29/11/2021

New Liverpool Primary School (SSD-10391)

Request for additional information

Drawing Title
ELEVATIONS - BLOCK X

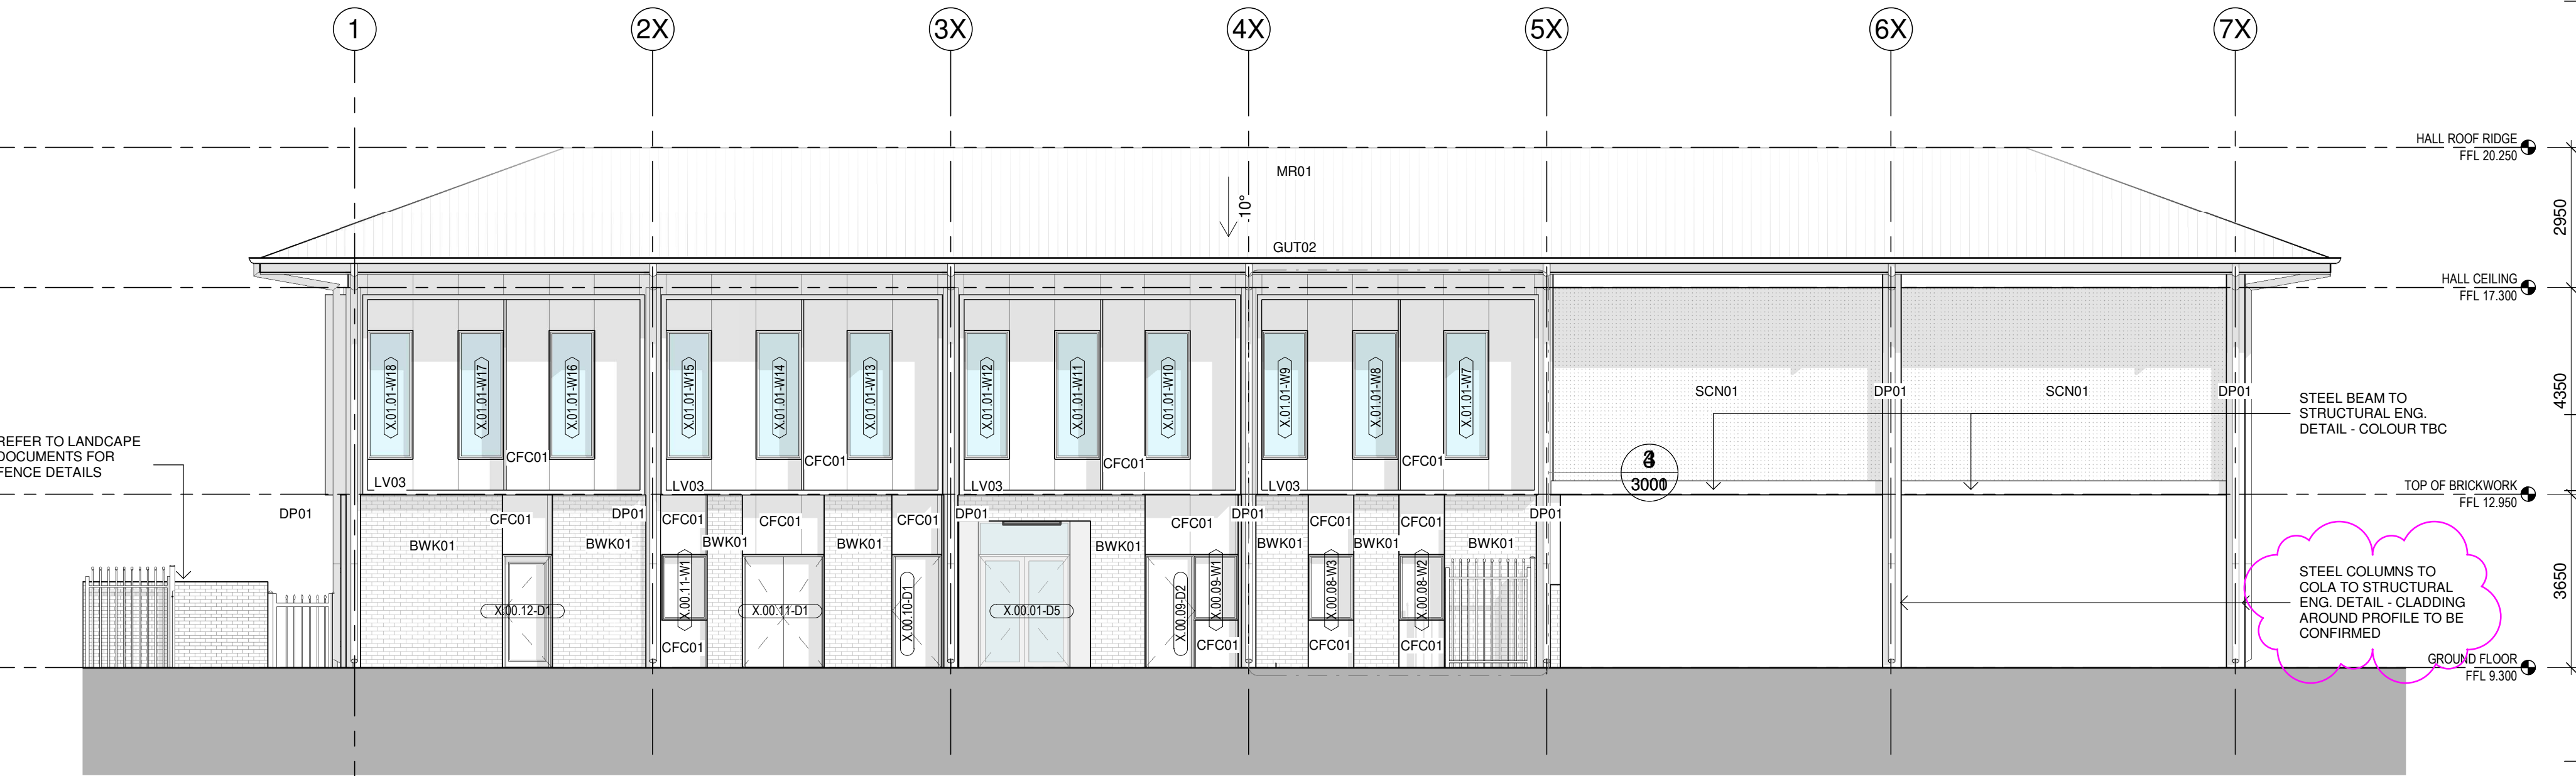
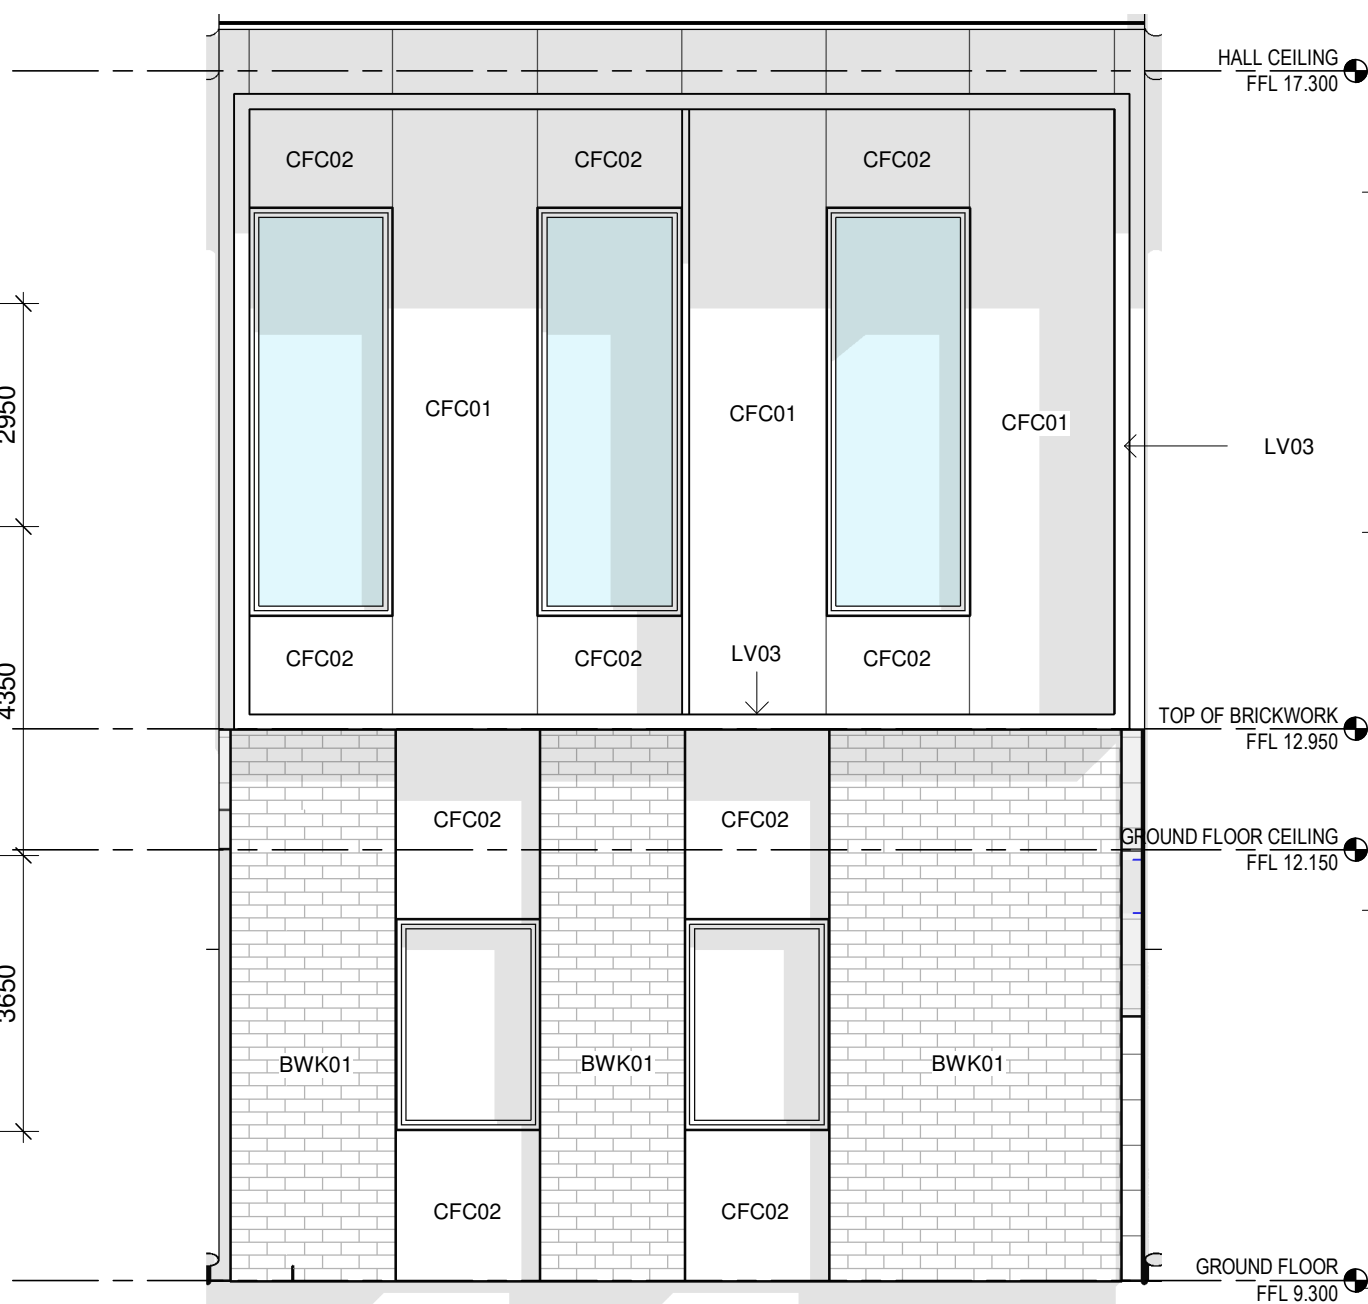
- the western façade should have additional external sun shading and drawings should be amended to include this feature.
 - the current bike parking location results in bikes being transported through the courtyard or the hardstand gate. The bike parking should be relocated closer to the student entry and away from the waste area to encourage a modal shift in the future.

NLPS-LA-SSD-3611-DRG

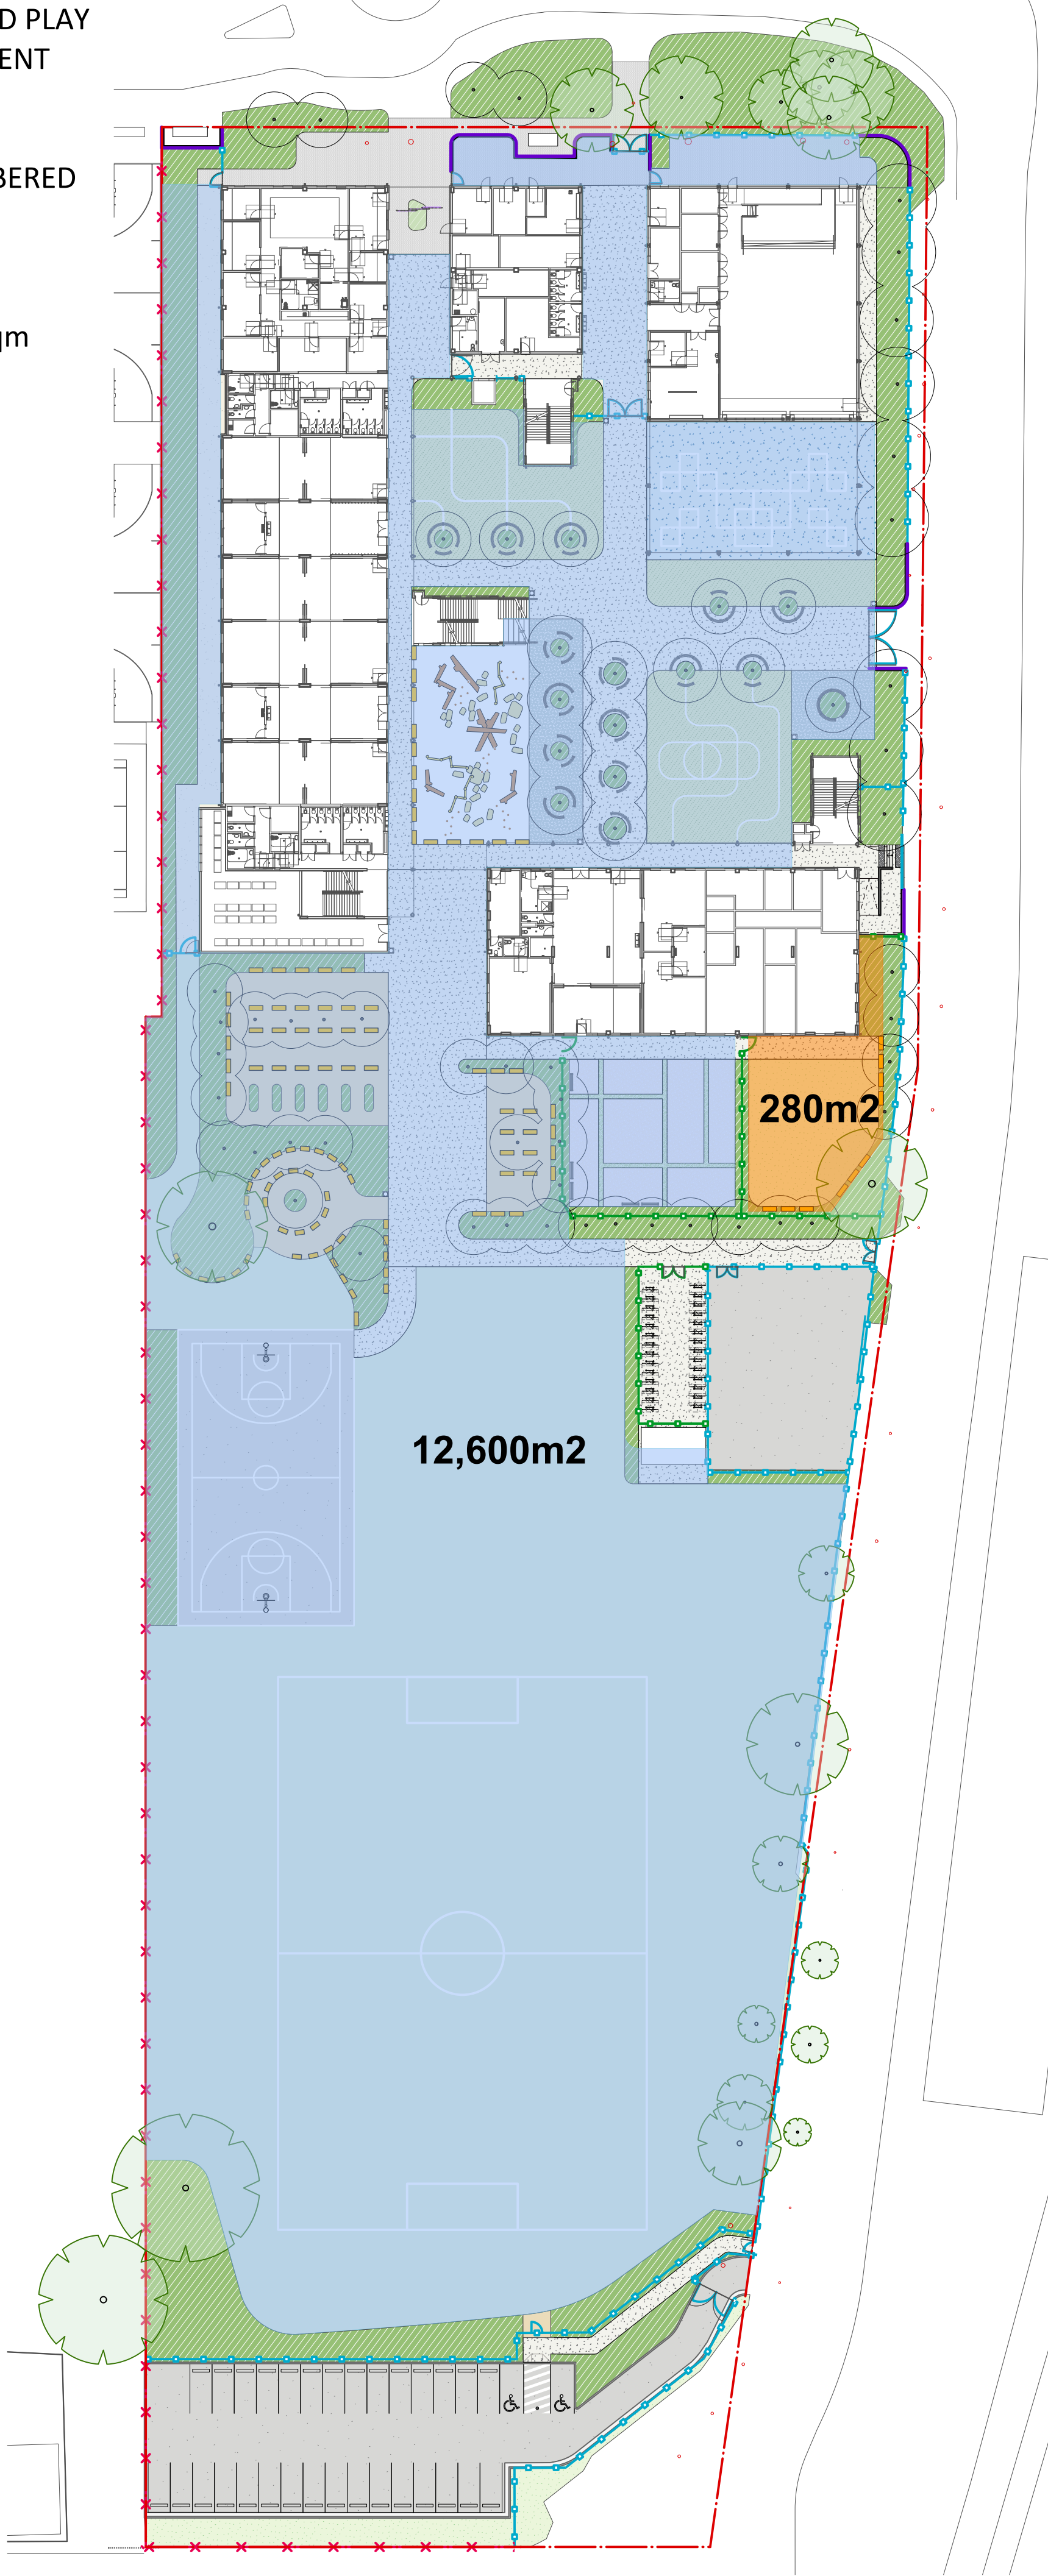
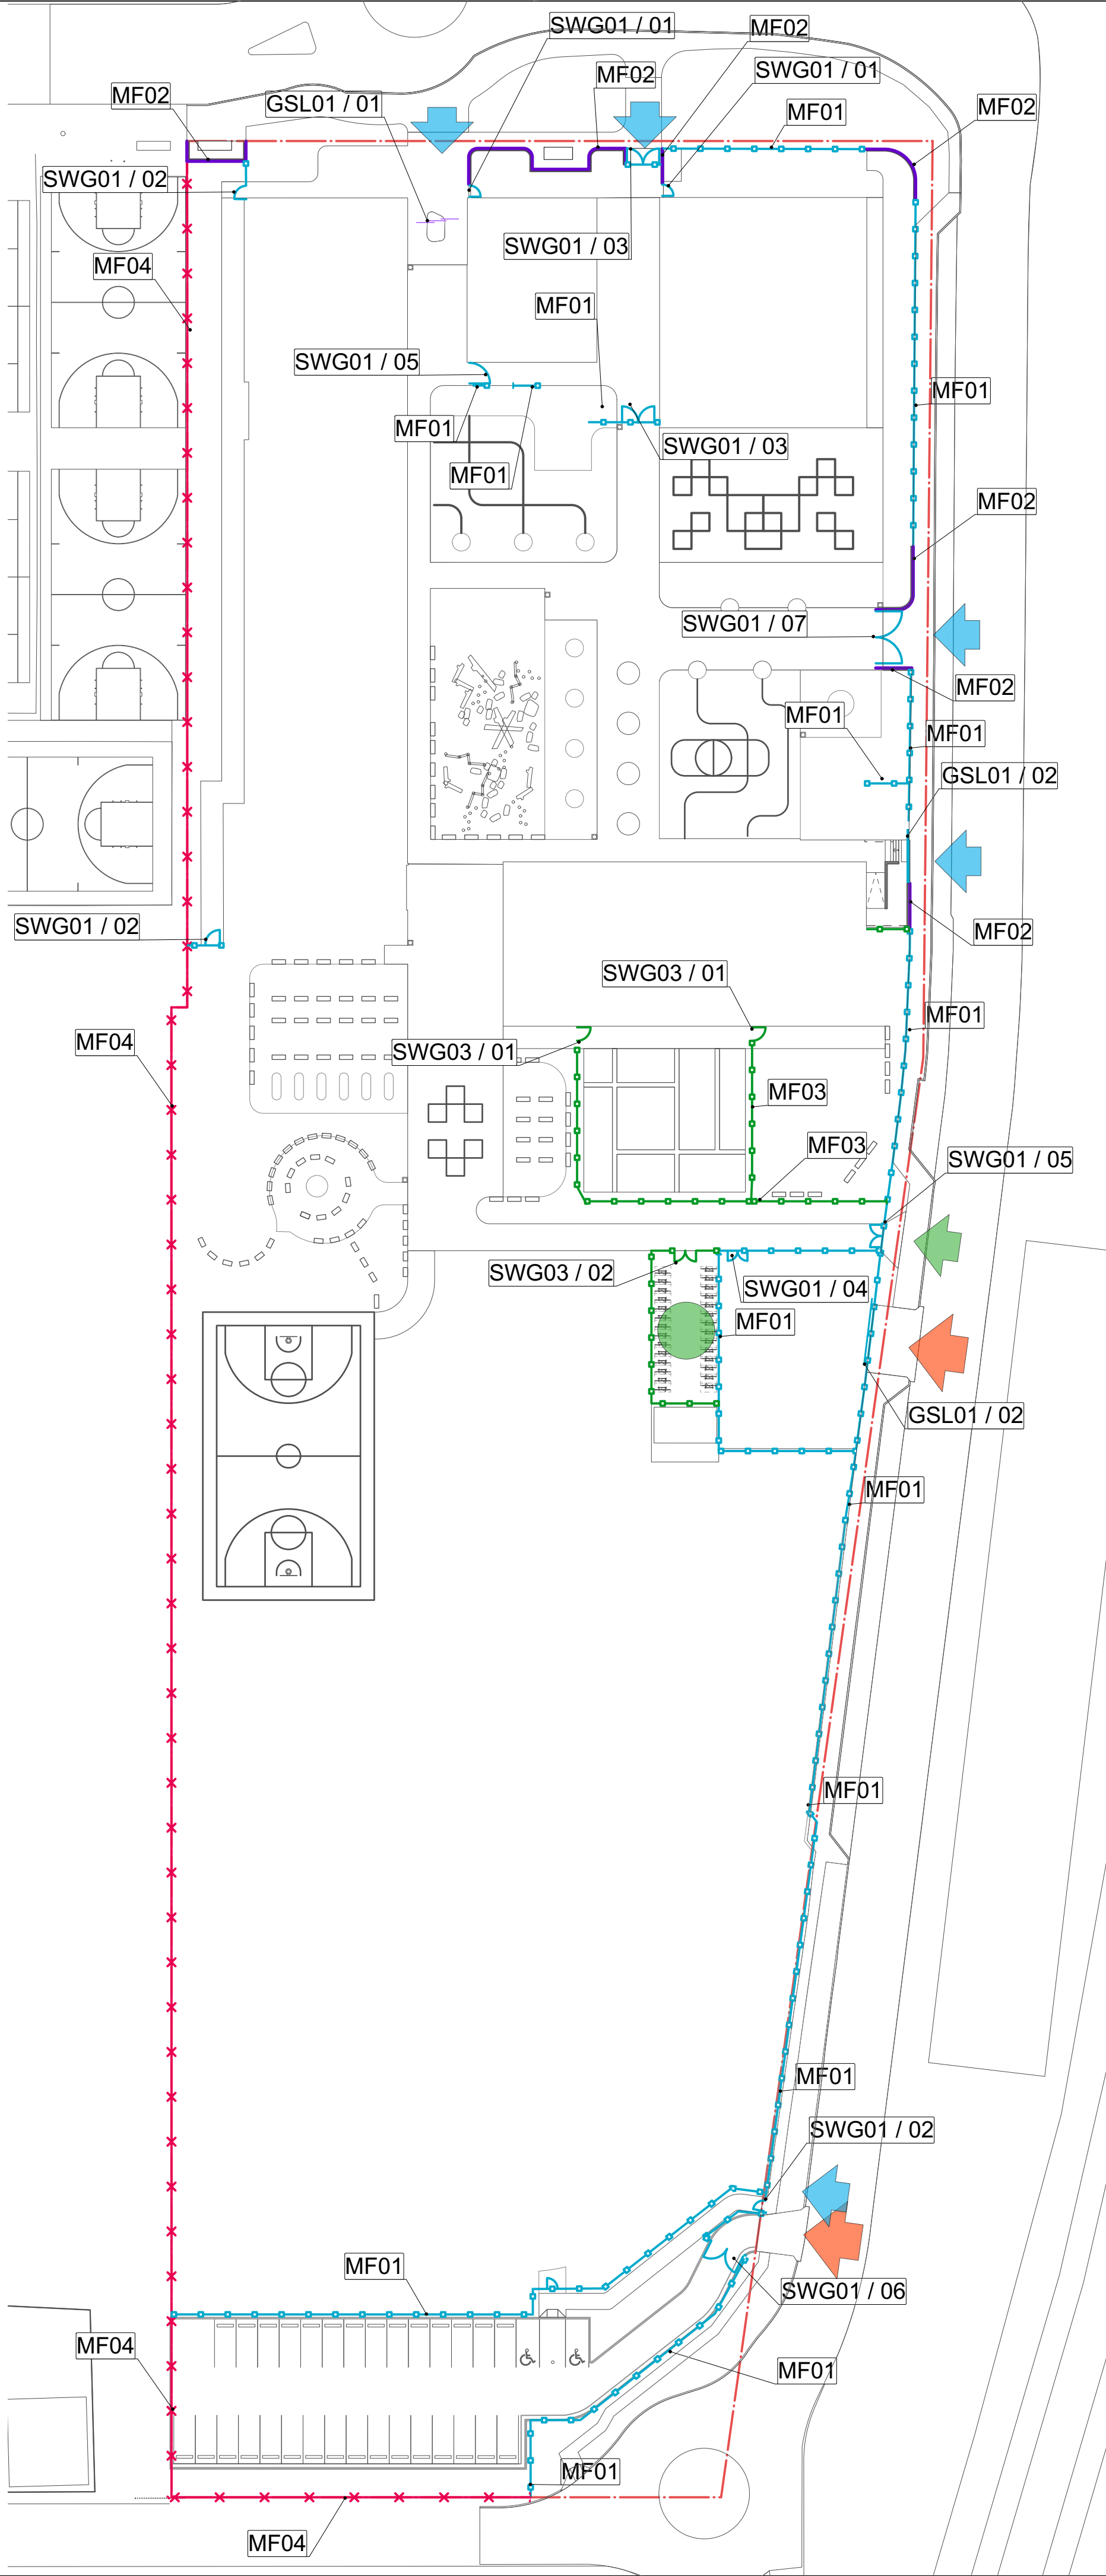
3. The location of the trees in the submitted drawings NLPS-AR-DRG-SSD-0202 and NLPS-LA-SD-0101-DRG(05) are inconsistent. Please submit consistent landscape and architectural plans.
